Whalley Parish Council

3/2012/0826 Proposal: 1 x Free-standing double sided internal illuminated forecourt sign

Location: 76 Mitton Road Whalley

OBJECTION

X = POSITION ON FORECOURT.

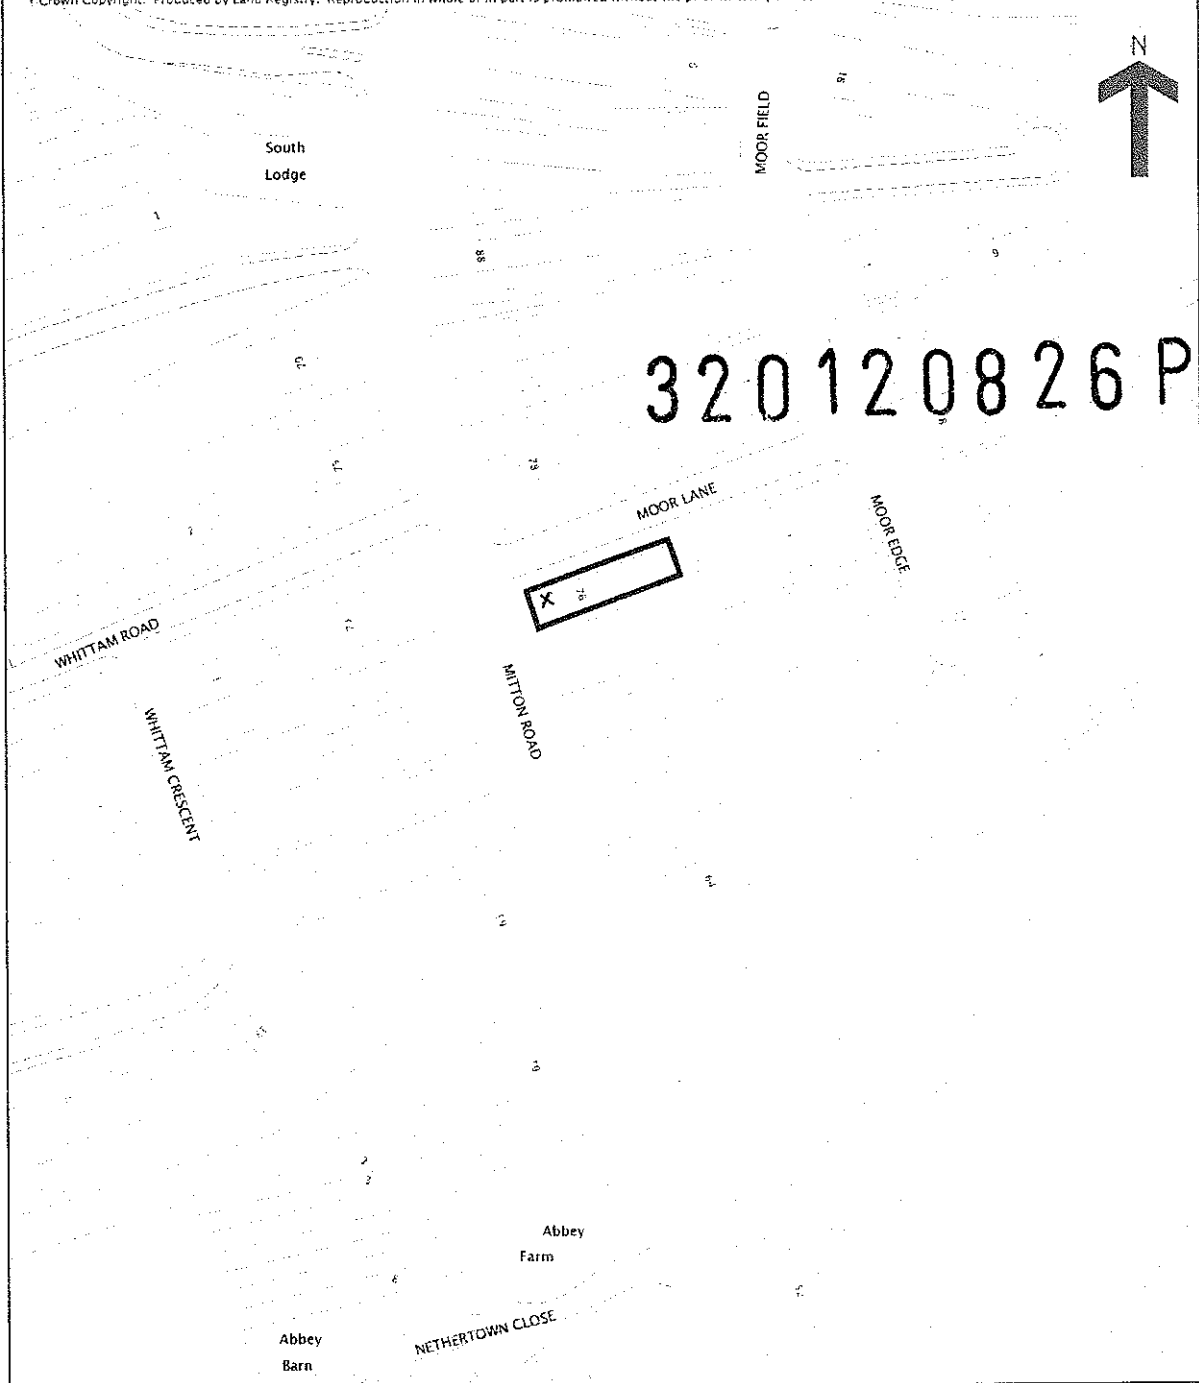
The parish council consider that the proposed free standing illuminated sign in size and character is totally inappropriate to a residential area. The proposed location of the sign will prove to be a significant traffic hazard. Motorists exiting Moor Lane onto Mitton Road will be unable to clearly see oncoming traffic. Furthermore a highly visible sign may prove a distraction to passing motorists.

Policy G1 of the Districtwide Local Plan in the interests of highway safety and the safeguarding neighbouring residential amenity would be ignored if this application were to be approved.
